**Our Case Number:** ABP-314602-22

**An  
Bord  
Pleanála**

**Date:** 20 July 2023

**Re:** Windfarm development of 14 no. turbines with 110kV electrical substation and all related site works and ancillary development.

Job No.	Drawing no.	Revision
6225	6225-PL-100	A

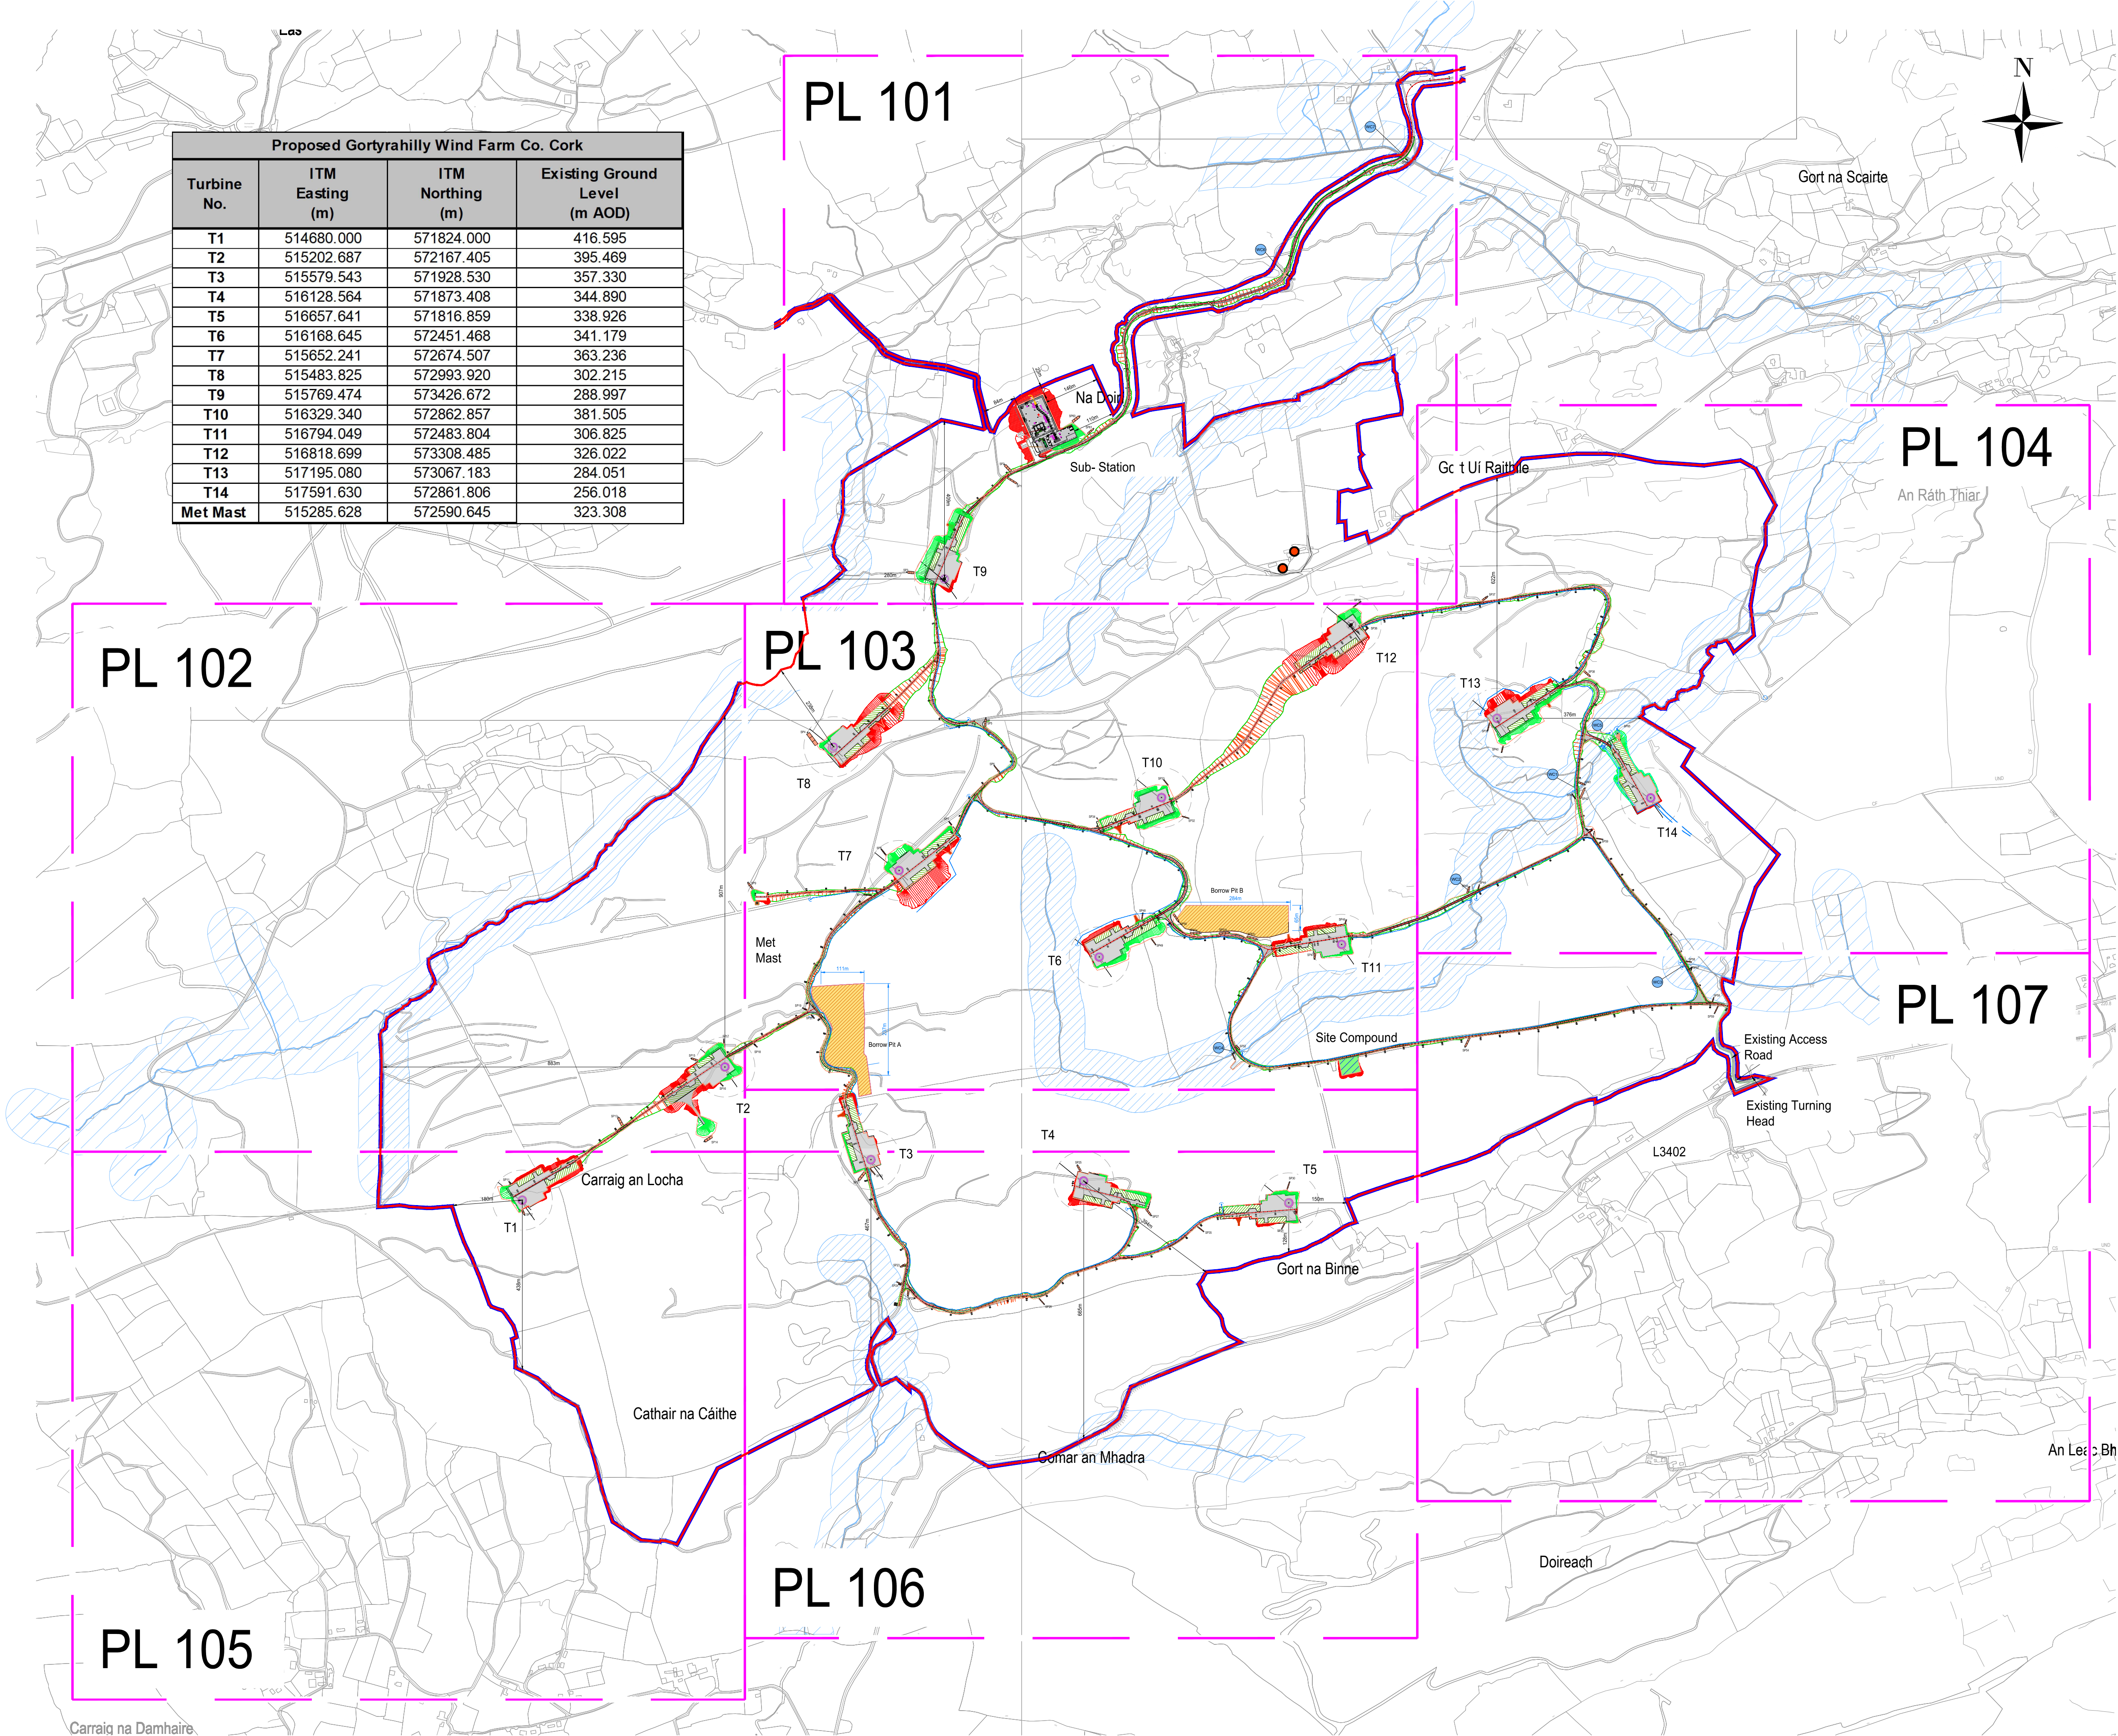
- (a) Identify the exact location of those dwellings on the Site Layout Key plan (Drawing No. 6225-PL-100).
- (b) Confirm if these dwellings are located within the red and/or blue line of the proposed application.
- (c) Provide letters of consent, and/or any other relevant information from the existing landowners agreeing to the information in the application.
